The Potting Barn
No.5 Hobbs Court
Bilsham Rd.
Yapton

Ref .application Y/80/25/S73Land West of Bilsham Rd. Yapton ref recent additions regarding drainage and layout.

OBJECTION

As - Plot 23
Front Elevation

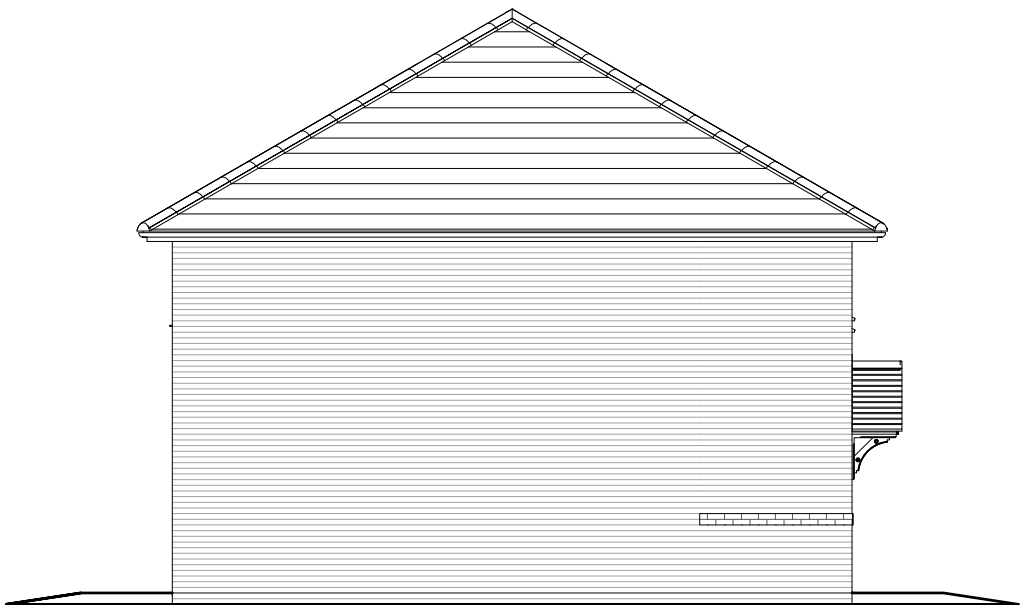
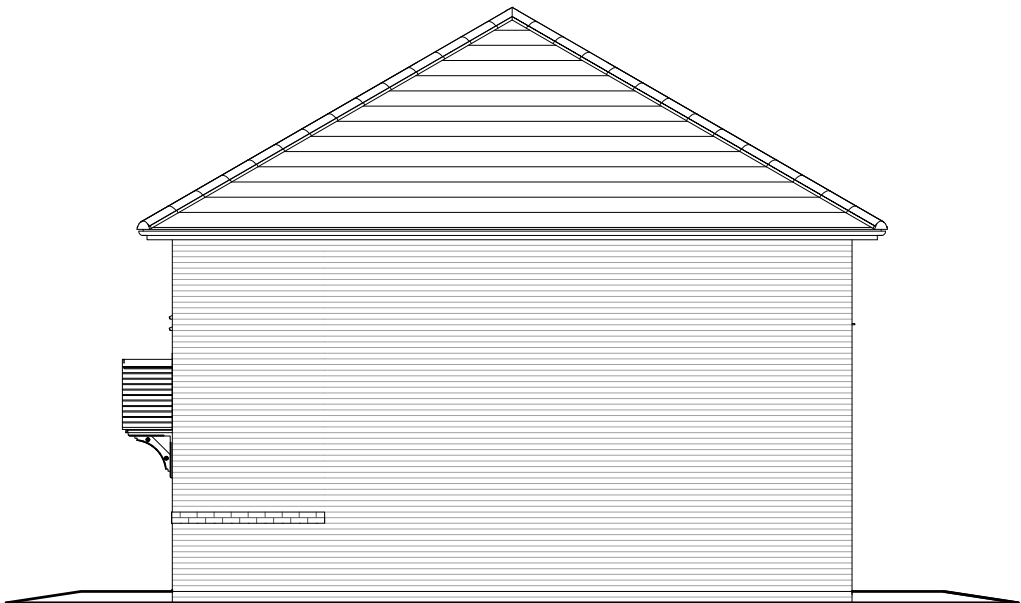
*'It appears that the land here will be raised from around 1.6m with FFLs of 7.6m. (1.47 increase), at plot 26, and 7.1m. (1m increase) at plot 25. I note that the approved FFL for the flatted building North of plot 26 was 6.125m. **The increase for plot 26 is concerning given it will face ground and first floor lounge windows (and a ground floor garden to these flats).***

*It is not clear as there are no garden ground heights shown on the drawing but I am assuming that if plot 26's FFL is 7.6m. that its garden will be raised accordingly, in which case **there will be a considerable height difference between the site height and the street height to the North. How then will the raised earth be held up? Or is the garden to stay the same and steps to be provided to the ground floor level ?***
